Lachlan O'Reilly  
Planning and Infrastructure Manager  
The Hayesbery  
1 11 Hayes Road  
Rosebery NSW 2018  
20/01/2026

Subject: Badgerys Creek Quarry & Brickworks – Visual Impact Management Plan Nov 2025

Carl Dumpleton  
Team Leader  
Resource Assessments

D:\001\_NAS\_Data\GDM00\_Goodman\GDM01\_006\_ManagementPlans\GDM01\_006\_ManagementPlans.aprx | GDM01\_BComp\_Fig1\_SiteLocation

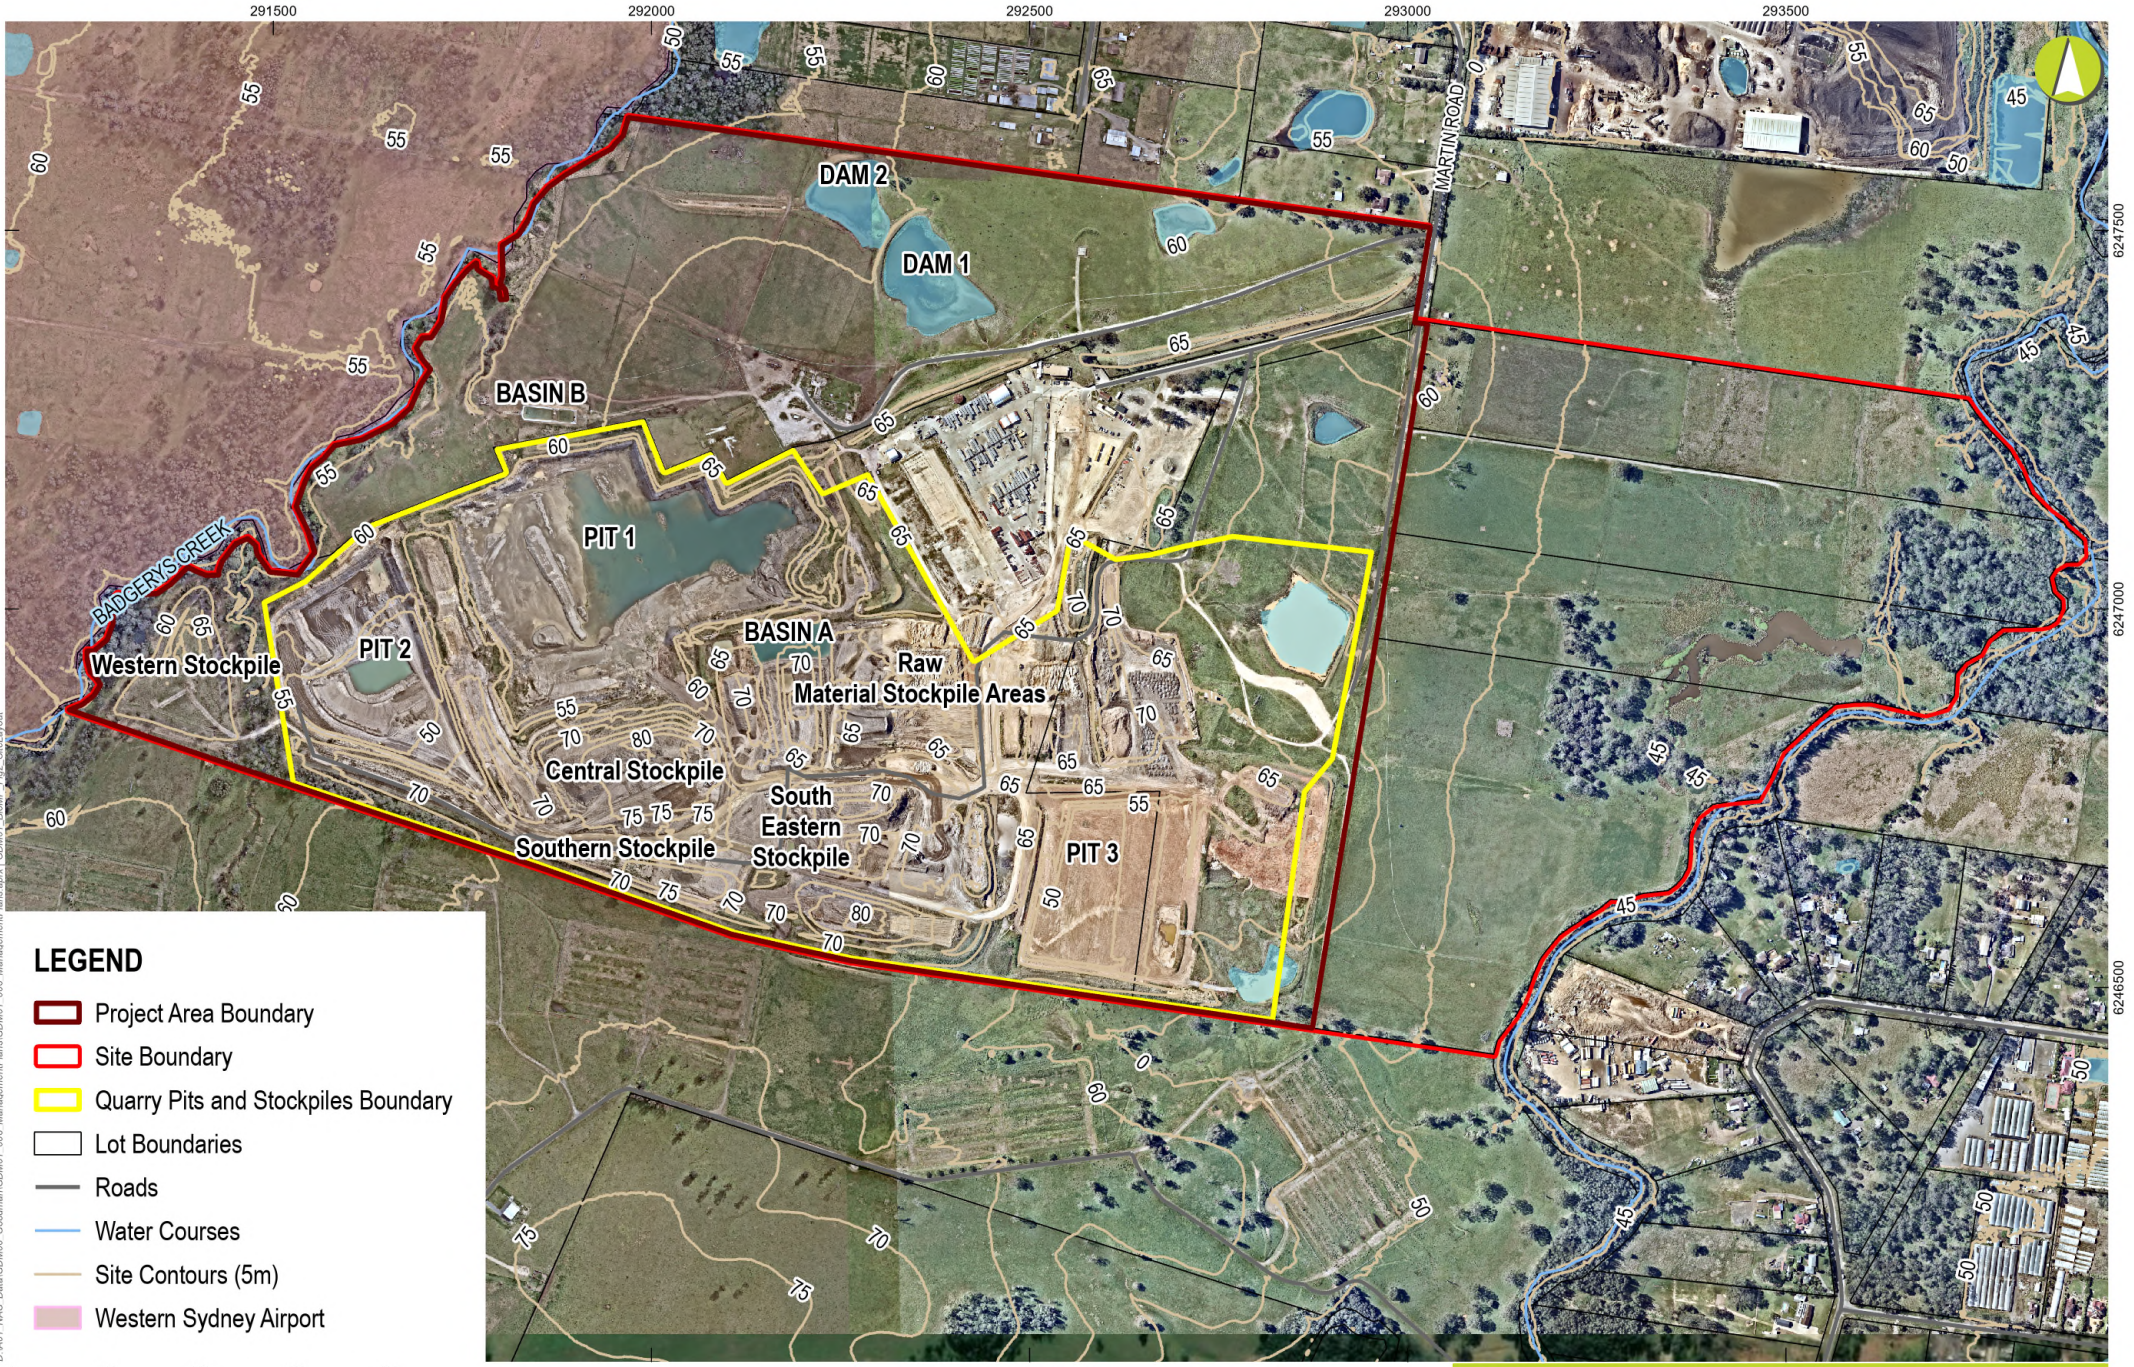
I have reviewed the plan in light of the reduced risk associated with the activities currently undertaken at the site and consider that it meets the relevant conditions of consent subject to the relabelling of Figure 1 and Figure 2 to reflect the "Project Area Boundary" and "Site Boundary" as per Appendix 2, Figure 1 of MP10\_0014.

Once this change is made and the document is resubmitted for information to the planning portal, it is considered approved.
